We are responding to the material found in Appendix E1: "Appendix E1 – Traffic".

**Figure 5: Network Traffic Volumes, with MPW S2 - Scenario 2**

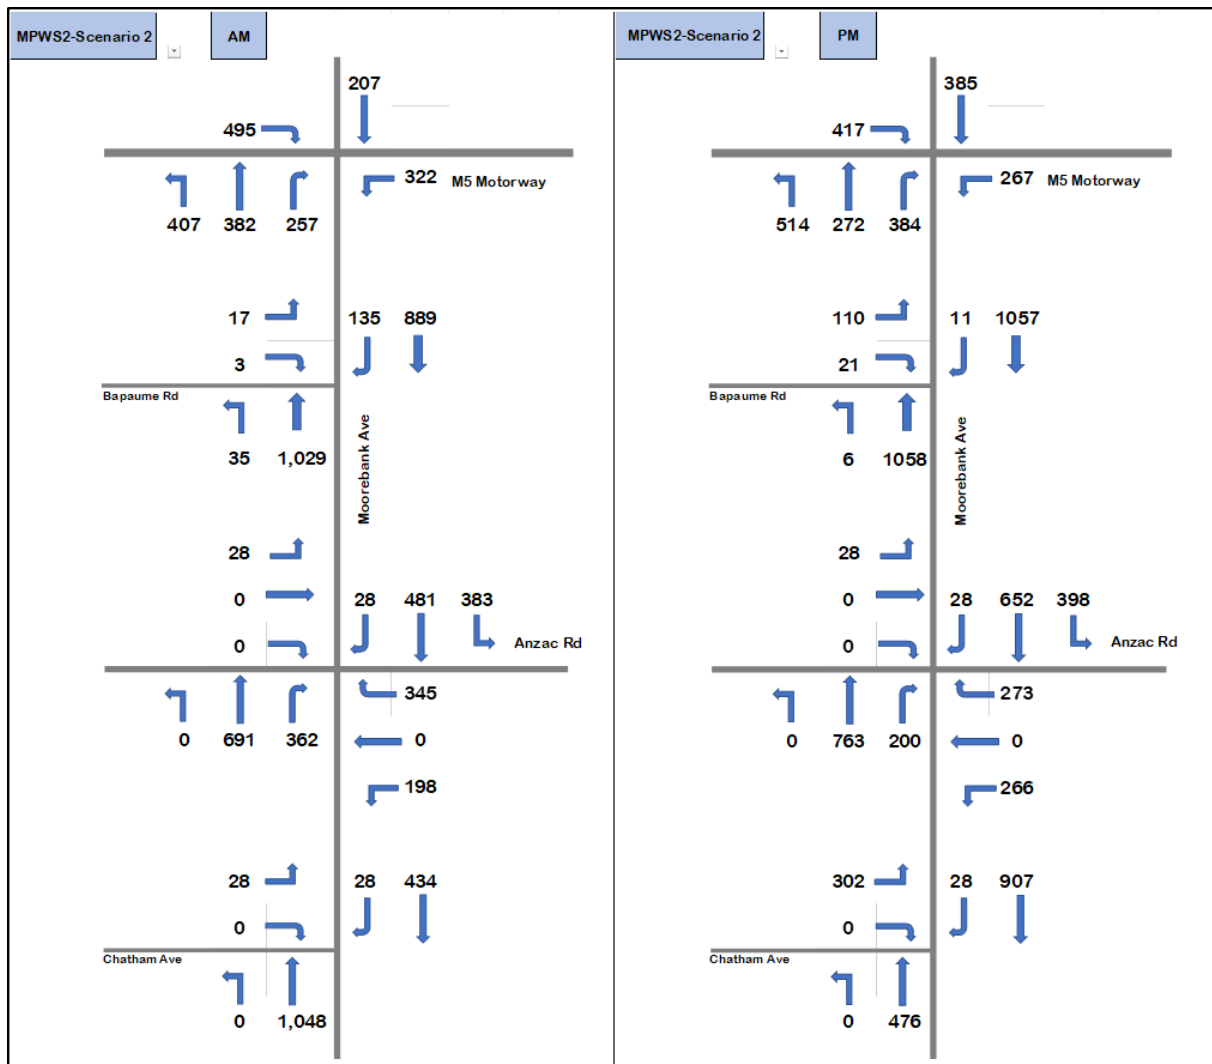
Figure 1 is reproduced from our original submission. It showed the traffic counts in the Ason report, which were based on a 2015 survey, together with the MICL surveyed counts (Moorebank Intermodal Company, Moorebank Intermodal Terminal Project, Environmental Impact Statement, Volume 3, October 2014), which was based on the 2010 survey.

Figure 2 shows only the movements that are reported in the Ason report, together with percentage increases and decreases when compared to the MICL numbers.

Natural growth over five years, combined with the activities around the Moorebank Intermodal will obviously increase the traffic flow numbers. These increases are: 43%, 55%, 68% and 84%. This range provides a sense of order of magnitude of expected increases in traffic flows.

However, it is counter intuitive to see **decreases** of 6% (right-hand-turn) and 38% (straight ahead) applied to the most critical intersection movements.

Therefore, the question is still unanswered: when the traffic numbers increase for other movements, ranging from 43% to 84%, why would the critical movements reduce by 38% and 6%?

Ason suggests: "For example, improvements on the broader road network at other locations remote from the study area may encourage regional traffic to use alternative routes that may then become more favourable, or there could have been localised changes to development on surrounding land— i.e. reduced intensification of use of sites within the Moorebank Precinct in preparation for future redevelopment."
